Re: Marist Catholic College, 270 Miller Street, North Sydney (SSD-10473)

We write as resident owners at [REDACTED] regarding our concerns about the above proposed Marist Catholic College development.

Title
SITE (ROOF) PLAN

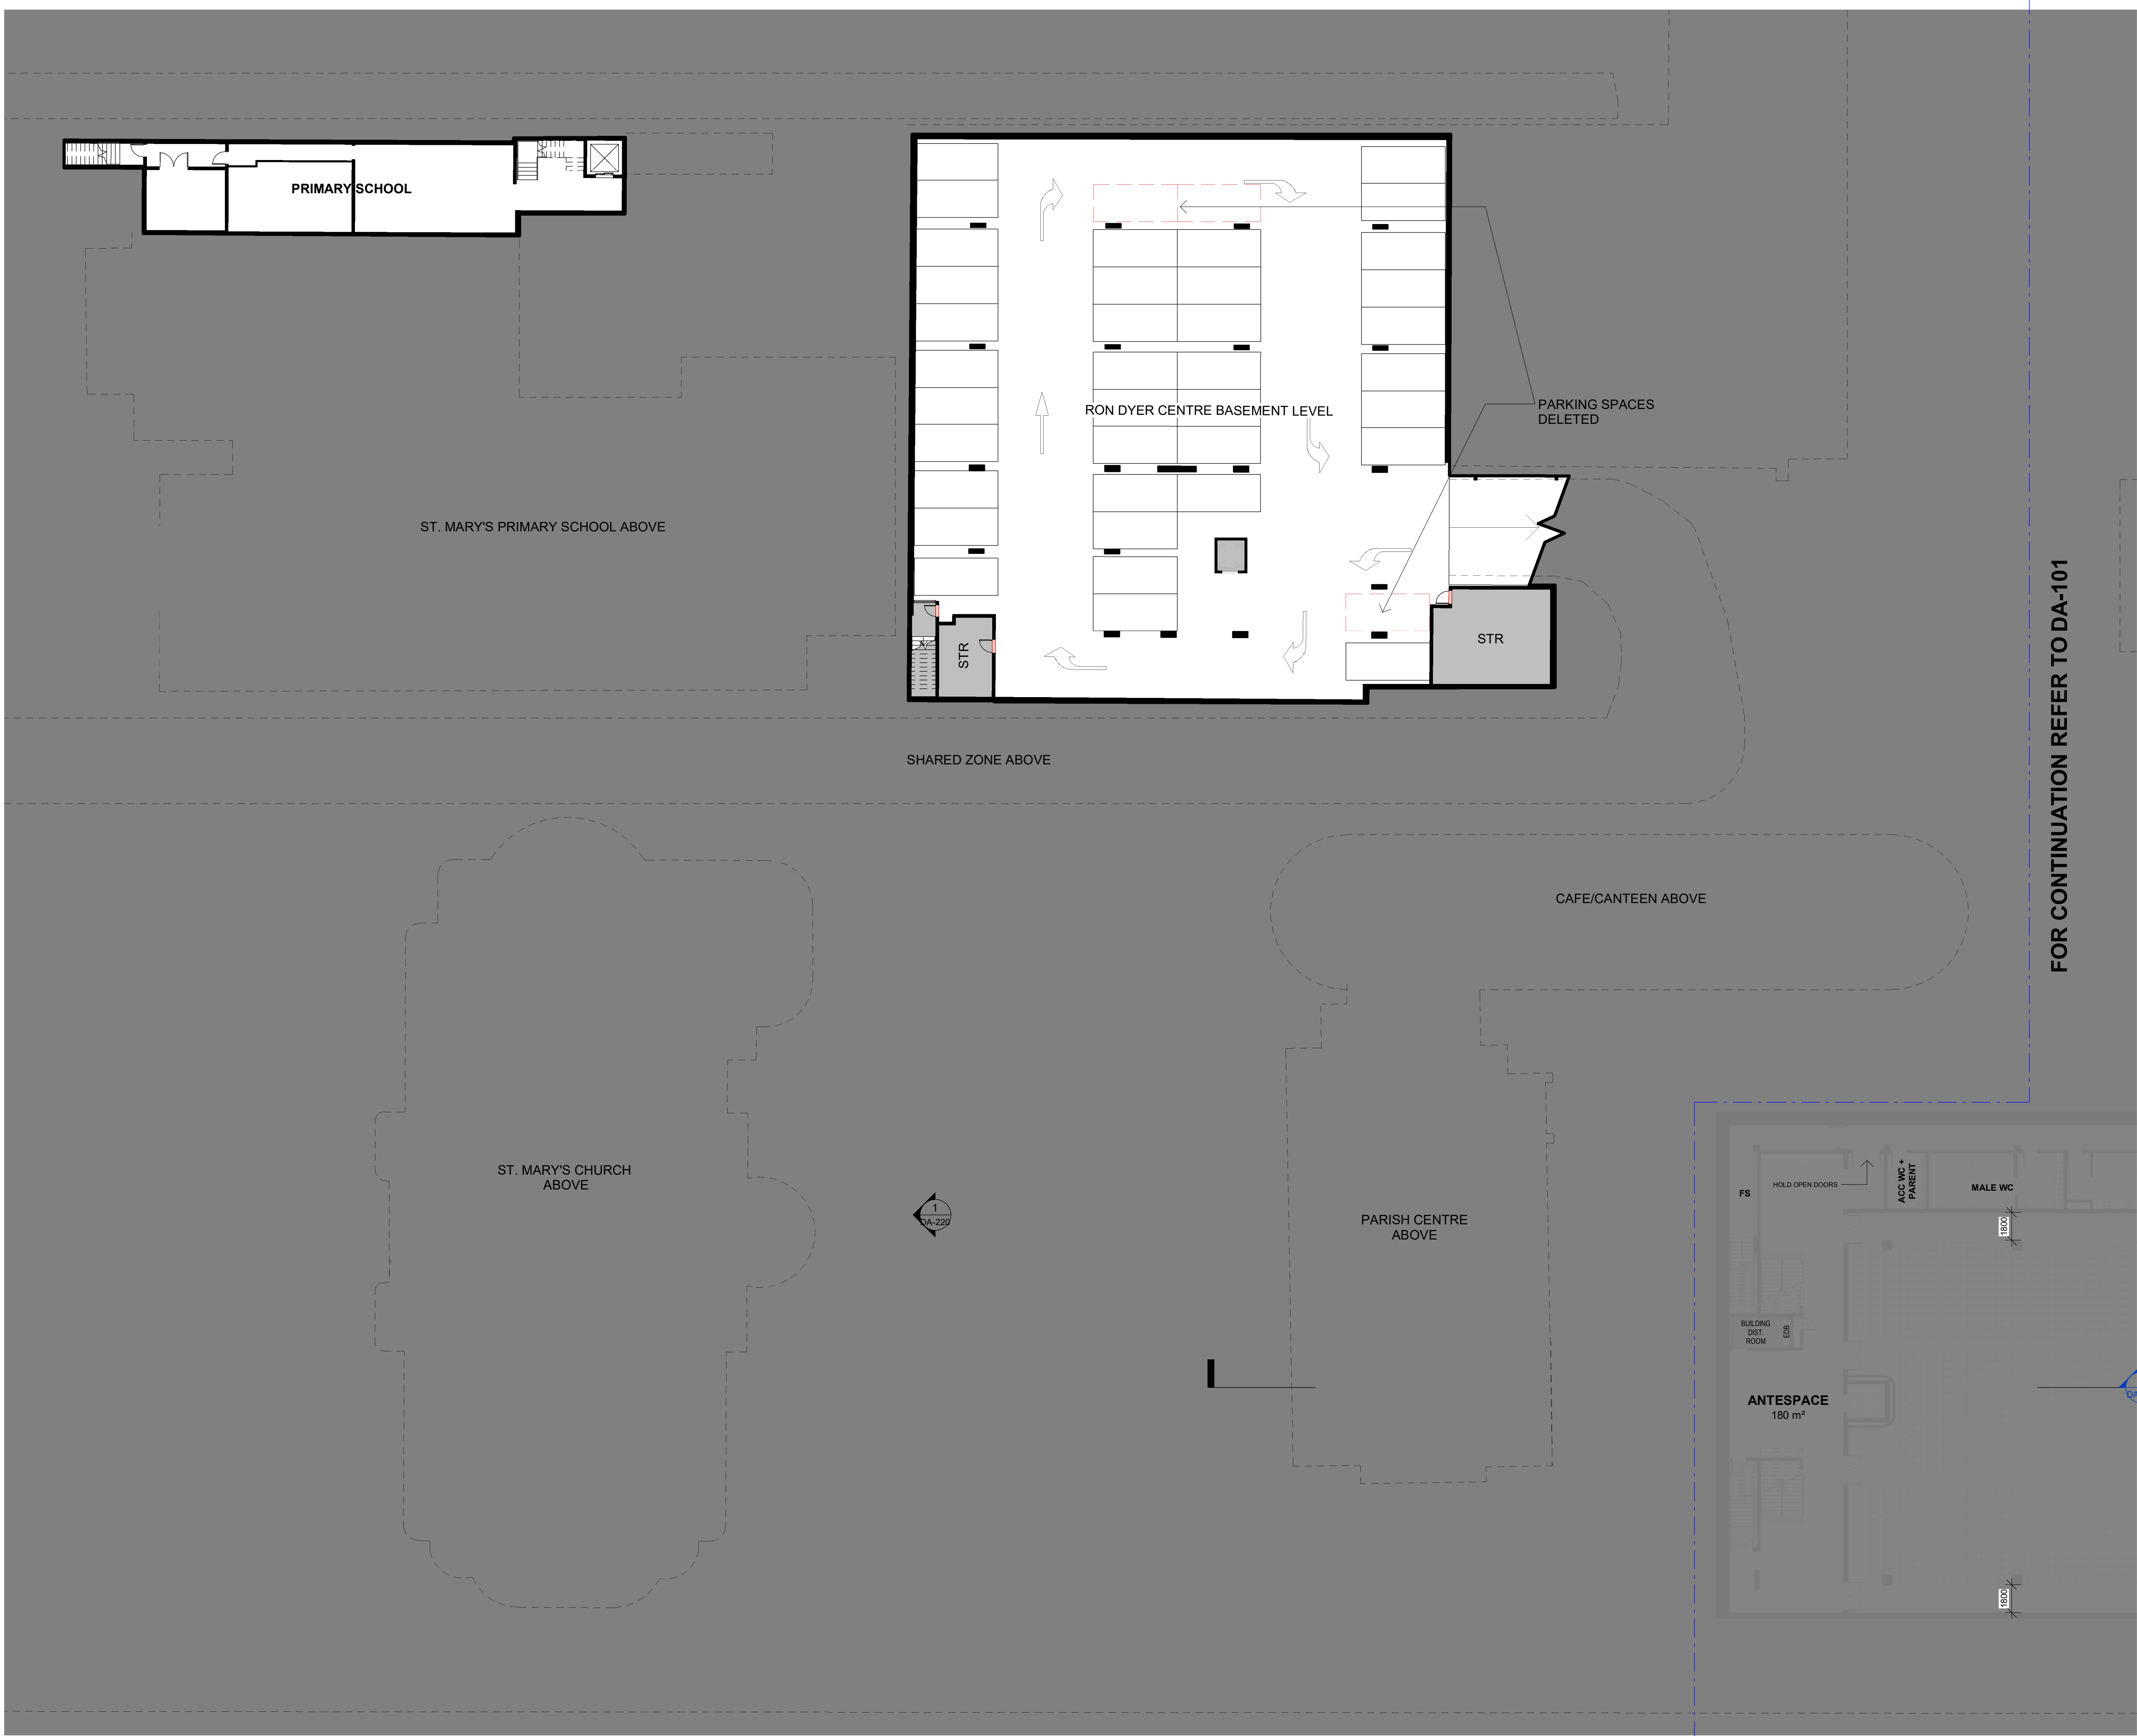
3. The rooftop of the new building on the corner of Miller and Carlow Streets has been designated for 'passive recreational' usage. It is not clear to us what this involves and there was a suggestion when we spoke earlier with school officials that this might include after-school sports activity like basketball and netball. We are totally opposed to this as it would severely impact on our lifestyle and we urge you to ensure that the college is made aware that such noisy activities will not be permitted on that roof area.

Title
GA PLAN - BASEMENT ZONE 1

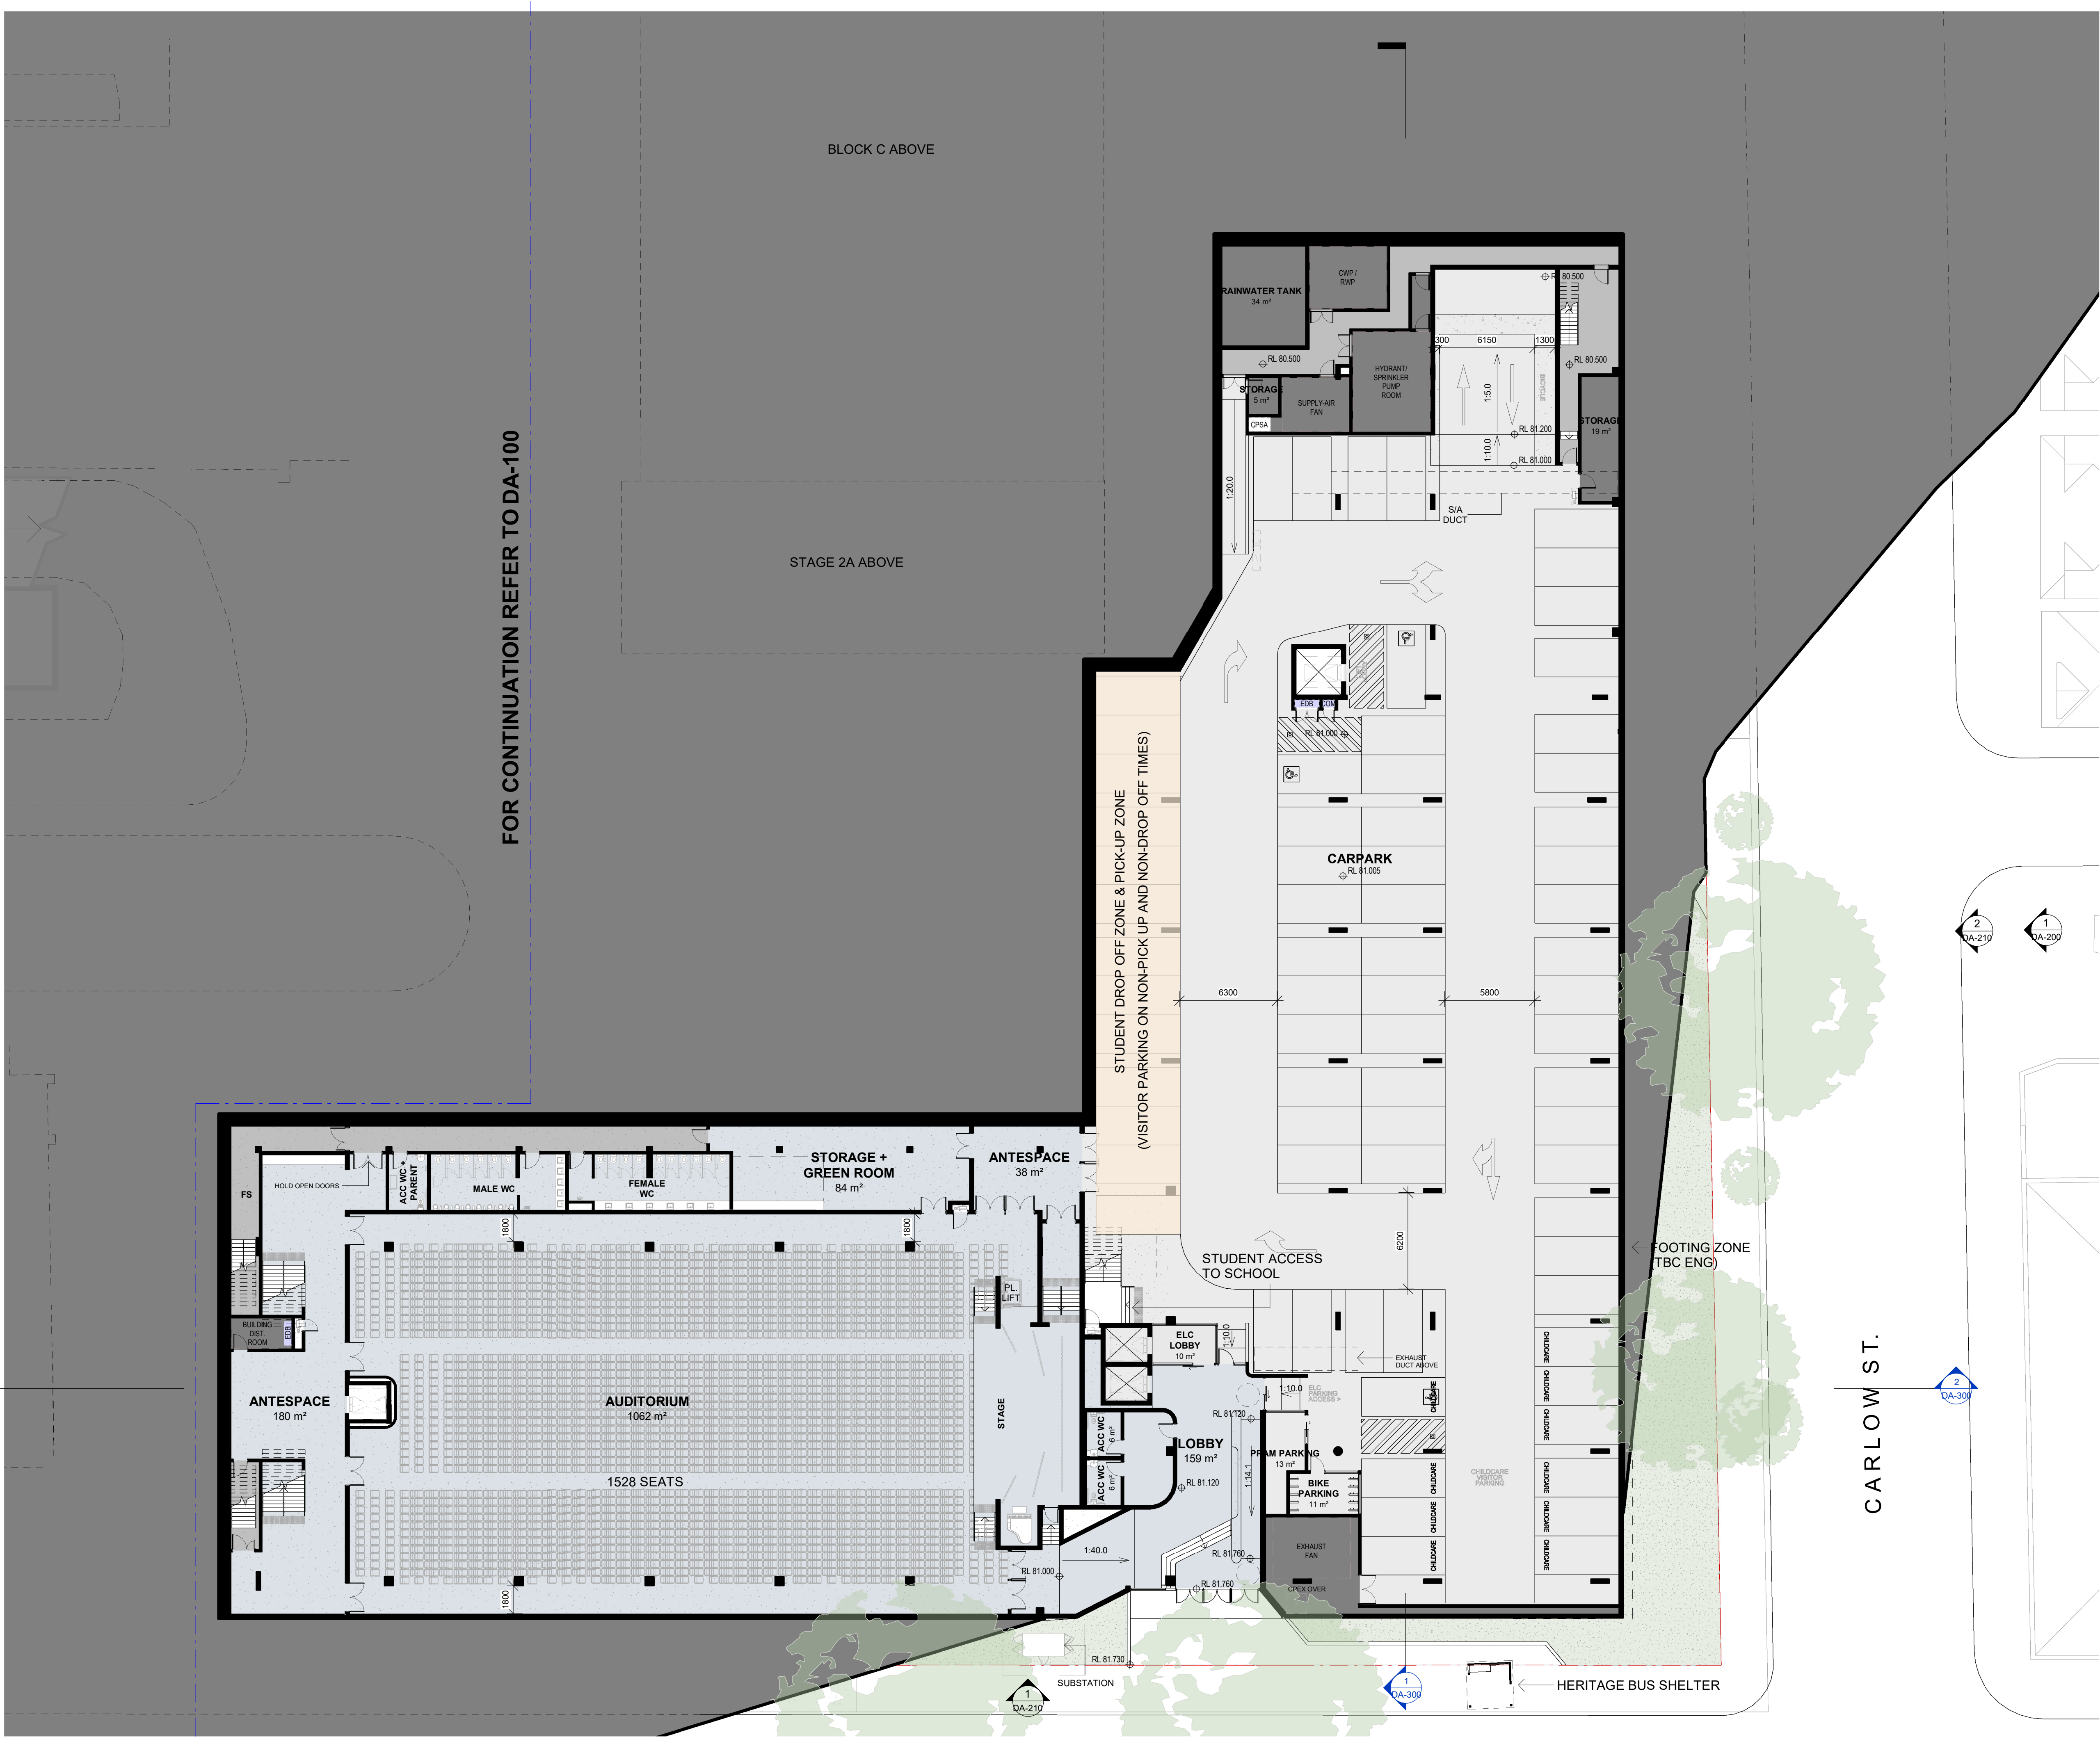
1. There are 71 car spaces planned within the 1st new 5 storey building. However, there are no car spaces planned for the 2nd new 5 storey building which will have an auditorium capacity for 1528 spectators. This raises the question of where the visitors will park, that warrants a response from those proposing the development.
2. As well as the development of existing structures, there are planned increases in the height of existing buildings and the removal of demountable buildings, which could present an issue with materials such as asbestos if not handled appropriately.
